# ENG-SF19004-R3-FDR-Redlines Summary\_Markup Summary

# ENG-SF19004-R3-CD-Redlines Summary\_Markup Summary

# ENG-SF19004-R3-SC-CD-Redlines Summary\_Markup Summary

# ENG-SF19004-R3-GEC-Redlines Summary

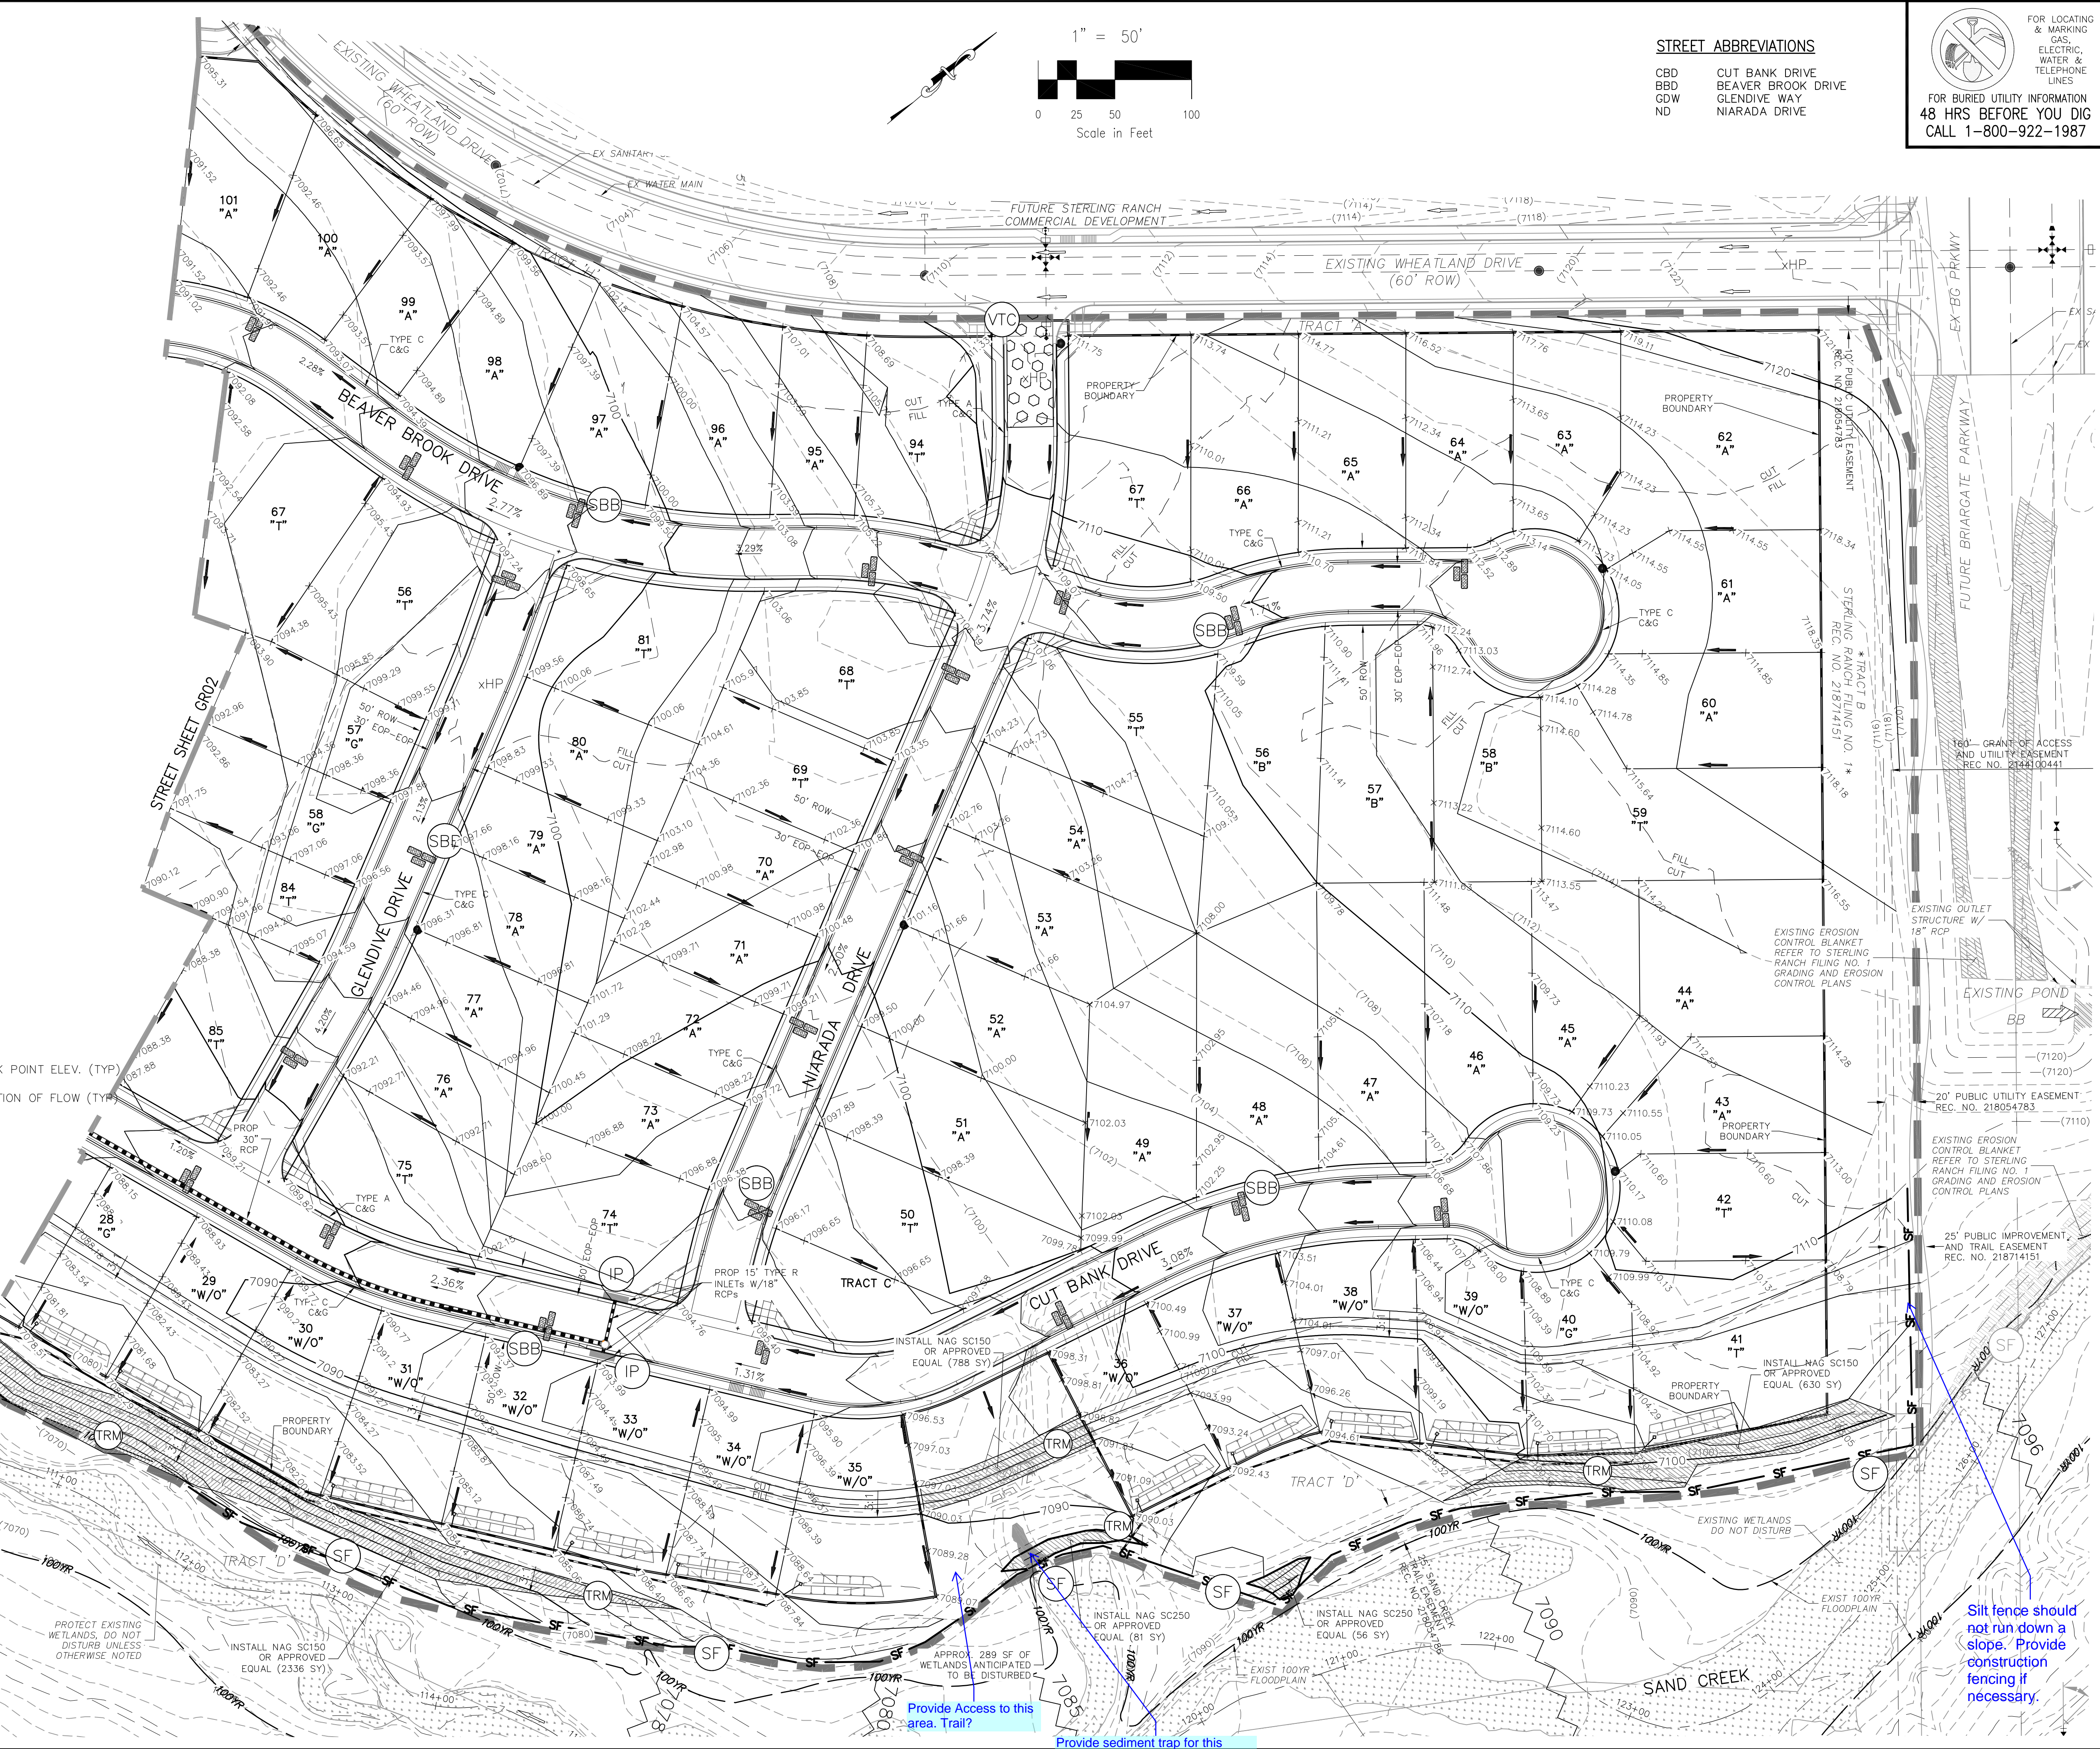
Provide Access to this area. Trail?

Provide sediment trap for this disturbed area before discharge into the wetlands.

Silt fence should not run down a slope. Provide construction fencing if necessary.

PROPOSED DRAINAGE MAP

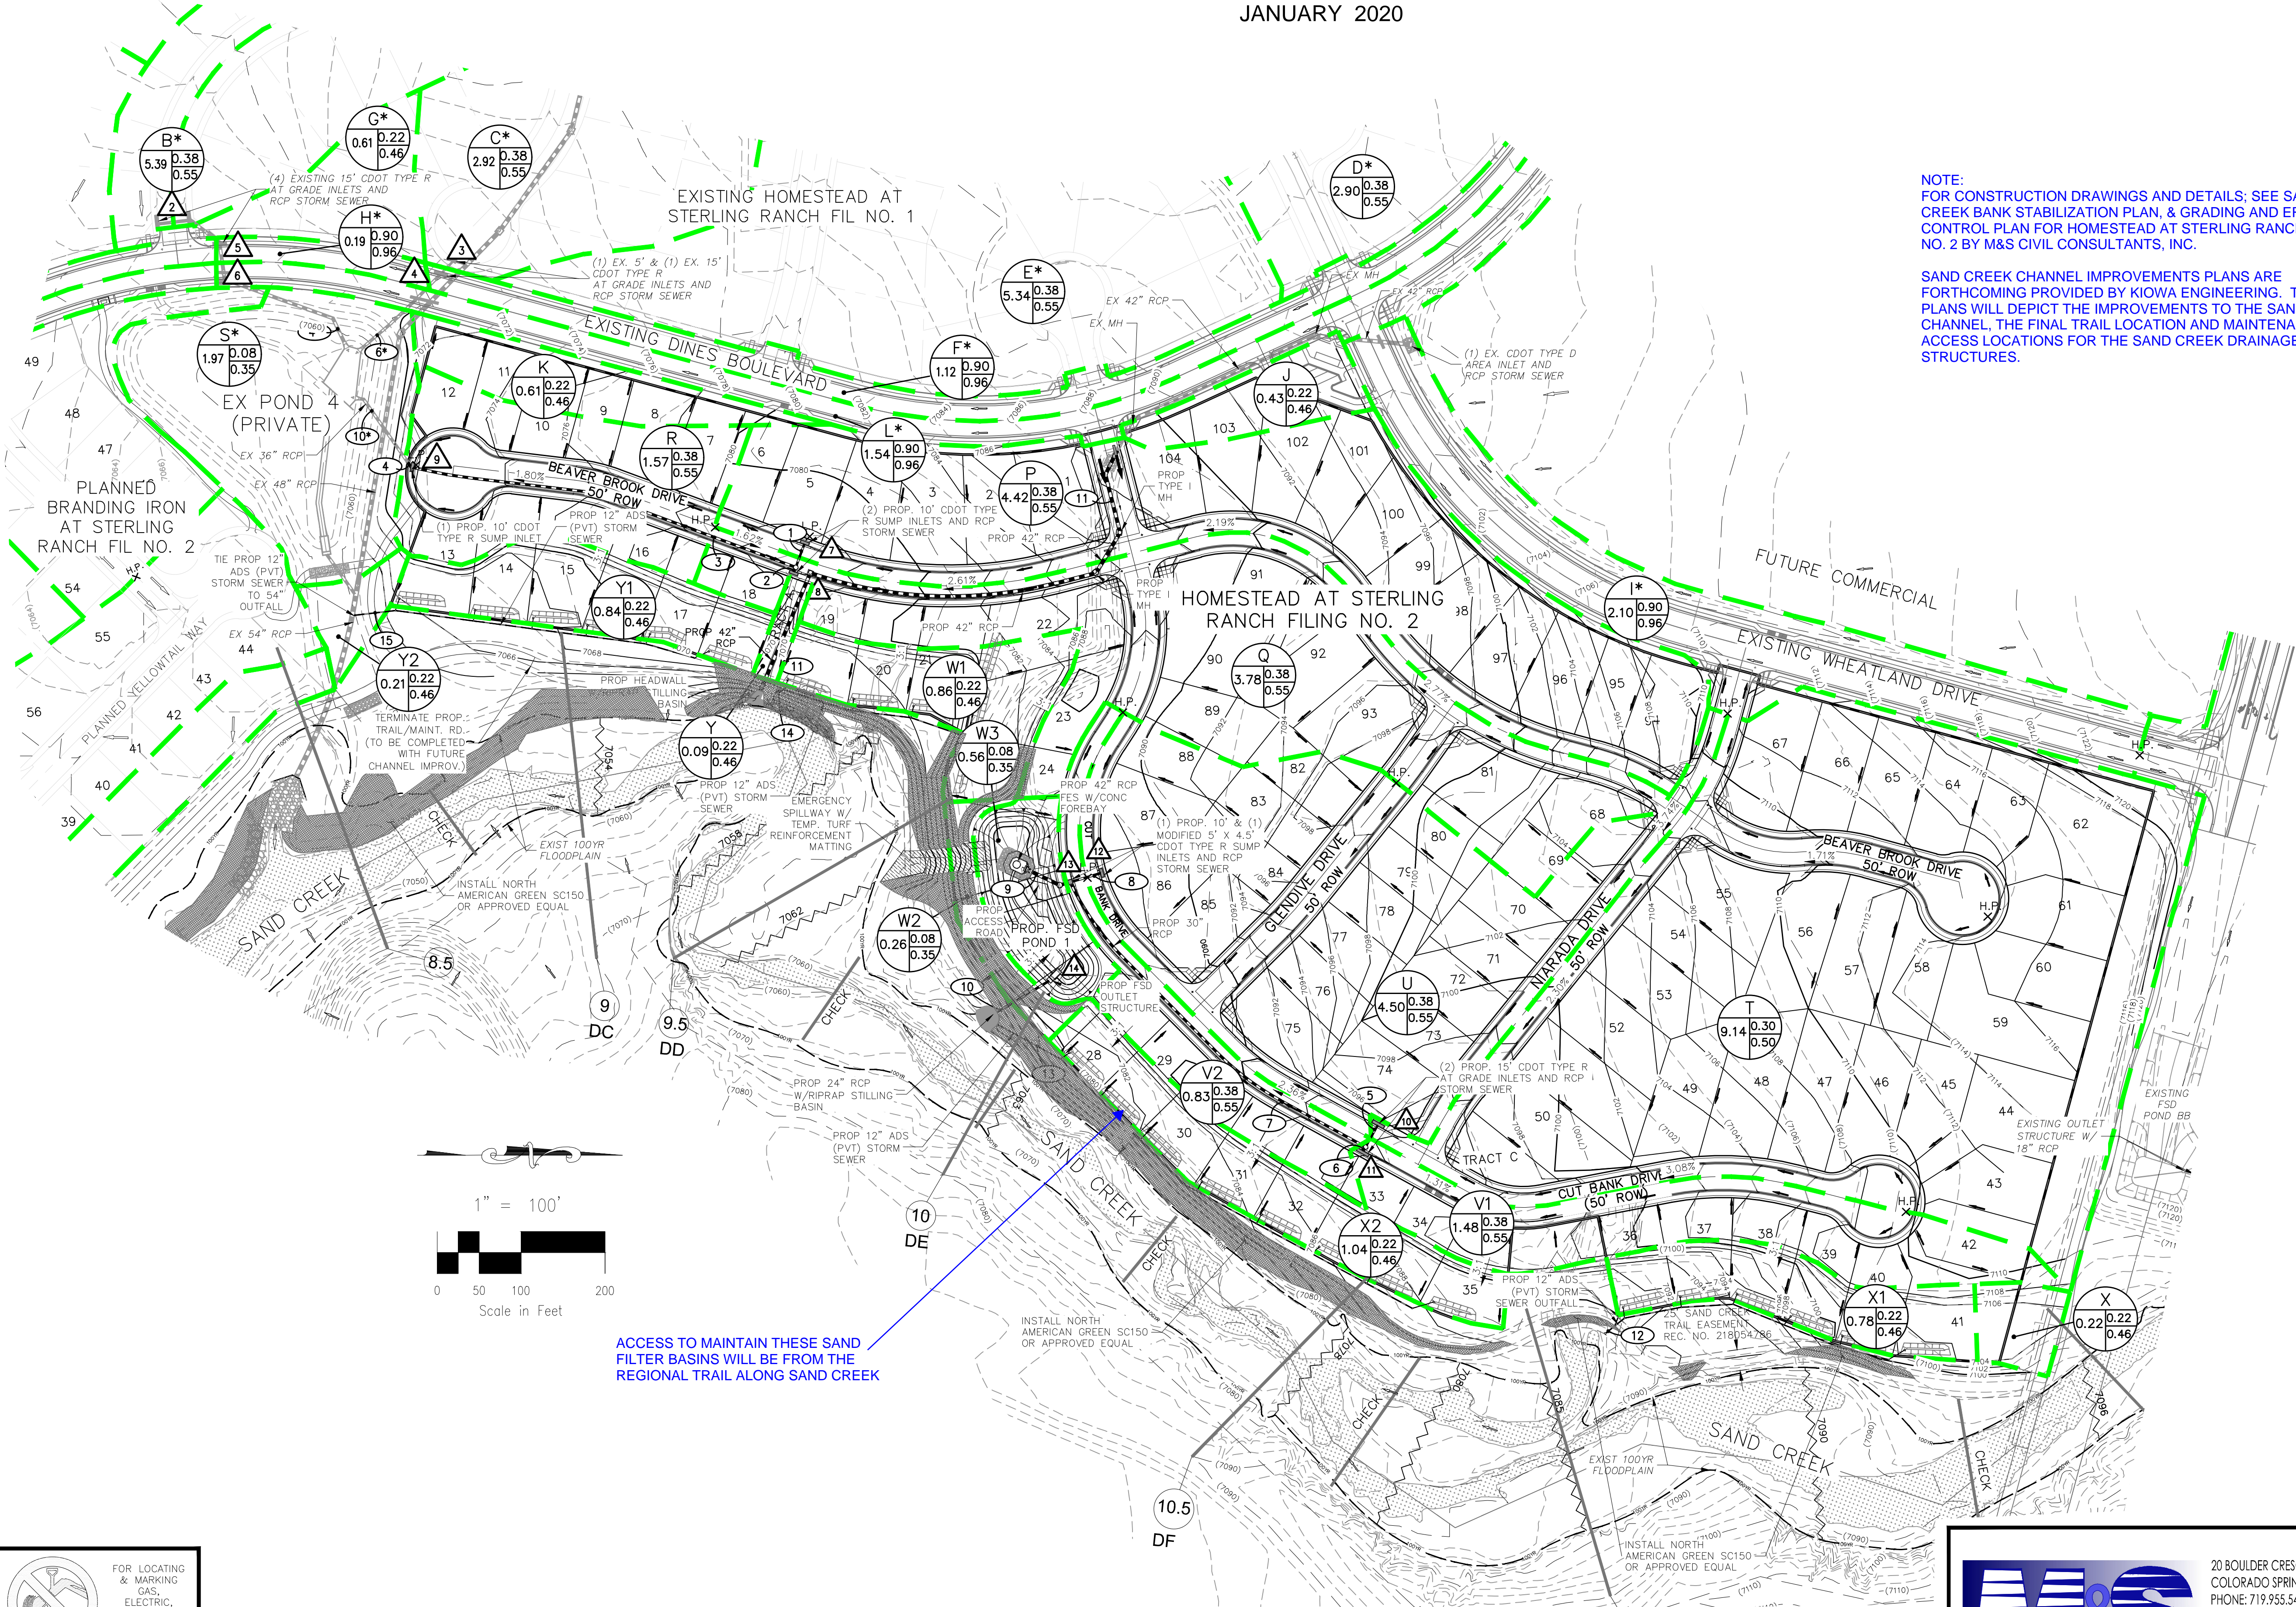
provide maintenance access roads

Provide a note referencing the initial channel design plans.

Provide a separate detail of FSD Pond 1 to show the access road, etc.

It appears that more stabilization (or spreading mechanism) is needed to the channel bottom.

Will the trail be utilized to access and maintain the SFBs?

Clearly show and label the proposed trail through the site.
